Our Ref: 15882
Council Ref: D/2020/610

**Response to Submissions
SSD 10362 (D/2020/610)
338 Pitt Street, Sydney**

On behalf of China Centre Development Pty Ltd, thank you for the opportunity to consider and respond to the feedback provided in your letter dated 14 September 2020 and in submissions made by State agencies and the public. The application has been amended and the following documents have been submitted under separate cover to address the matters raised by the City of Sydney and others:

Figure 8: Pedestrian wind speed measurement locations with comfort/distress ratings – Ground Floor.

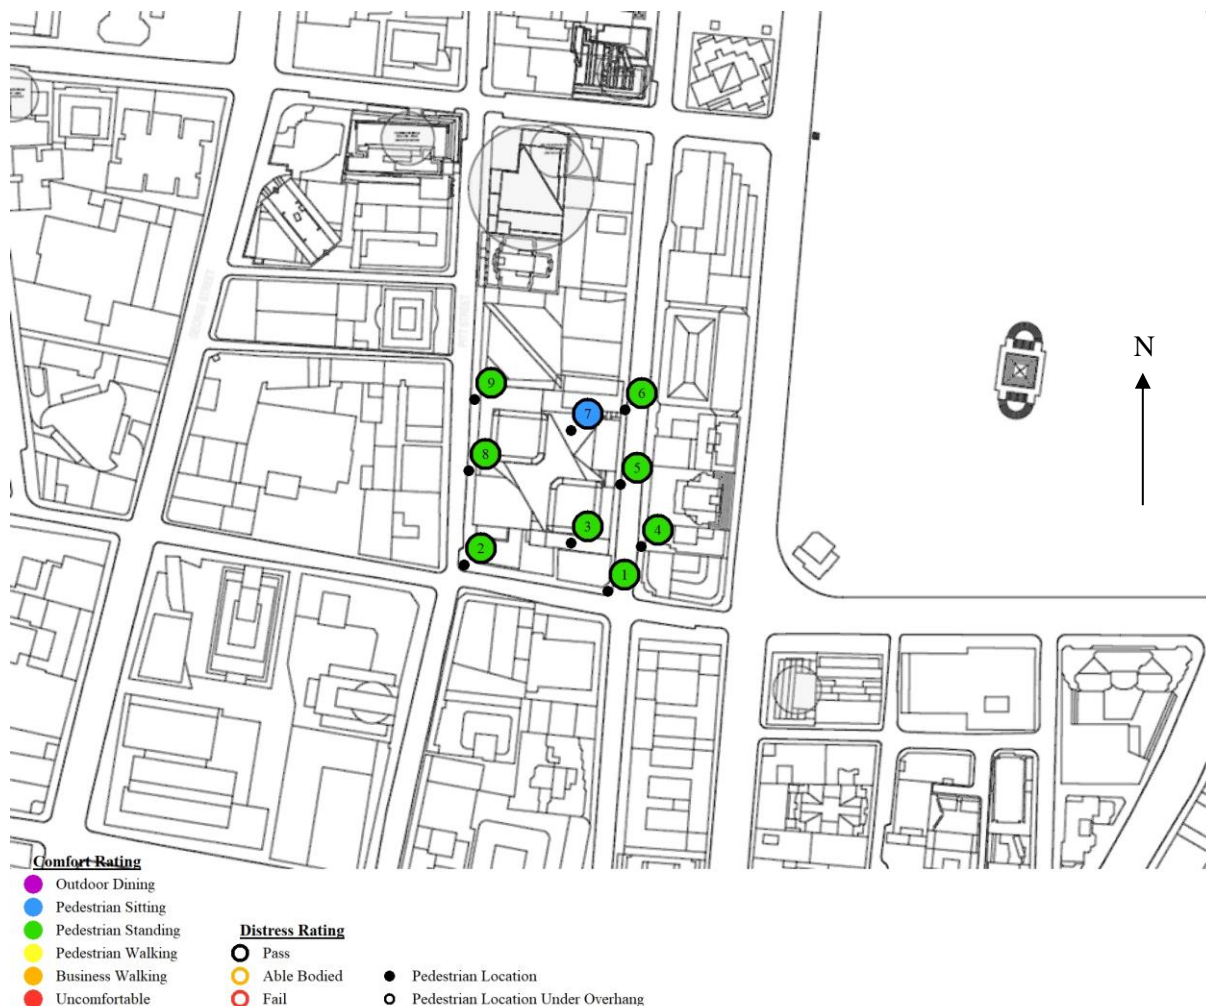
<p>9. Furthermore, concern is raised regarding wind impacts to the open space at levels 4 and 8, noting the following on page 22 of the wind report:</p> <p>The proposed perimeter landscaping for Level 8 will encourage improved wind amenity for this space. In addition, the following measures may be incorporated during detailed design with a view to achieving conditions suitable for pedestrian sitting:</p> <ul style="list-style-type: none"> Horizontal awnings or canopies, particularly near tower bases Fence-type structure or high balustrade at podium edges Vertical screening elements around dedicated seating areas, using a mix of solid and porous media Pavilion-type structures to provide localised calm areas 	<p>The Design Response outlines that the landscaped areas on the sky bridge and podium terraces incorporate the following wind amelioration measures:</p> <ul style="list-style-type: none"> Horizontal awnings at the base of the towers on level 4 and level 8. Podium facades extend a nominal 3m above the finished floor levels of level 4 and level 8. A mix of screening and planting is proposed throughout the terraces. Pavilion structures on podium levels. <p>The Memo prepared by CPP concludes that:</p> <p><i>"Given the context in which the general guidance for amelioration was given and noting the requirement for detailed wind tunnel testing to quantitatively assess pedestrian comfort levels, the proposed changes are considered to provide adequate allowance for wind mitigation at this stage."</i></p>

Figure 9: Pedestrian wind speed measurement locations with comfort/distress ratings – Sky Bridge.

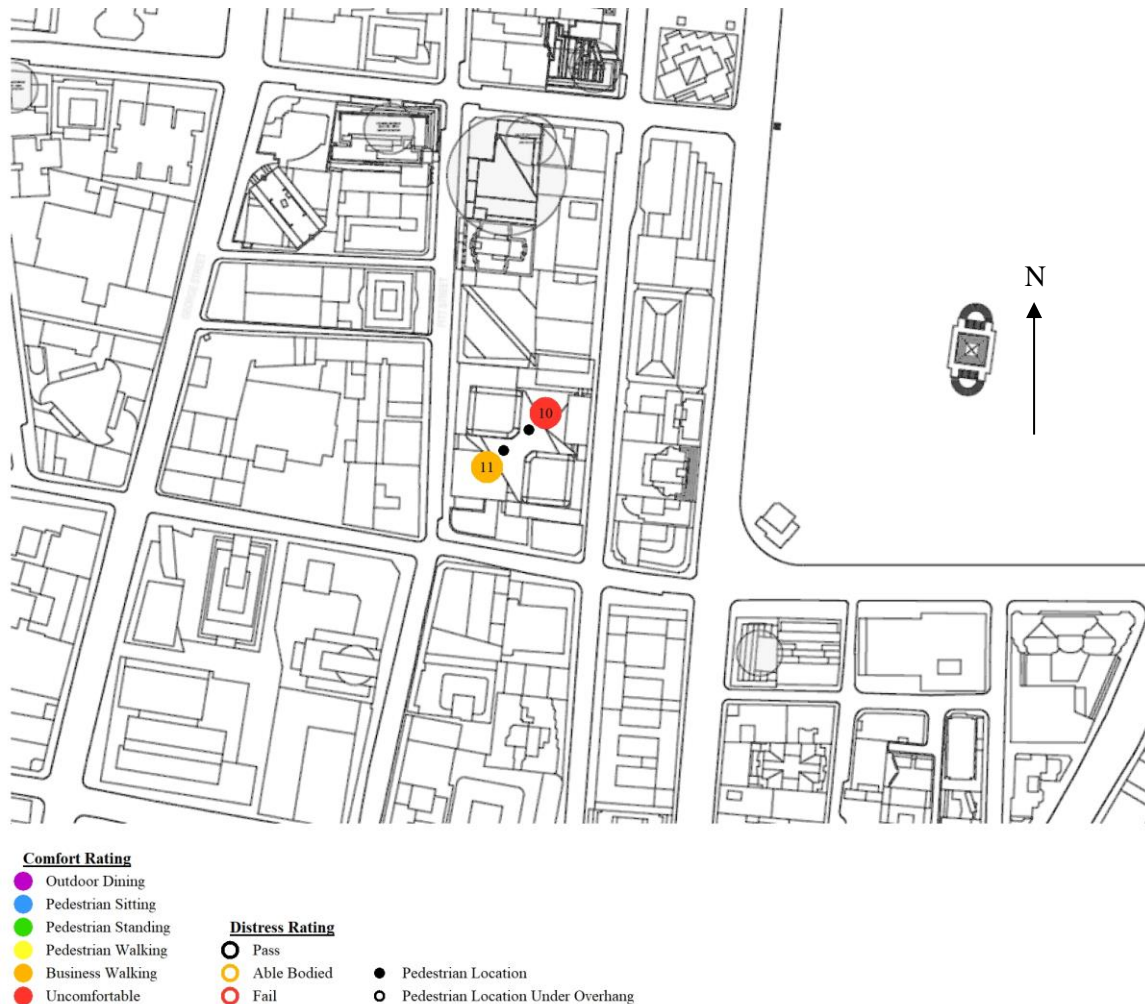
Item	Response
City of Sydney	
Urban Design	
1. The twin towers are striking and will be unique in Sydney. However, the City's Design Advisory Panel (DAP) has raised concerns specifically about the width of the sky bridge and its mass, as it visually works against the slim towers' profile by virtue of its overall width. It is recommended that the width of the sky bridge be reduced to no more than the necessary structural support for the towers. This will result in the reduction of floor area in the bridge currently allocated to a restaurant and/or hotel pool and amenities;	The width of the skybridge proposed in the Development Application is consistent with the width in the Architectural Design Competition. The structural design of the skybridge has been reviewed and areas have been identified for potential area reduction. Refer to the Design Response prepared by FJMT.
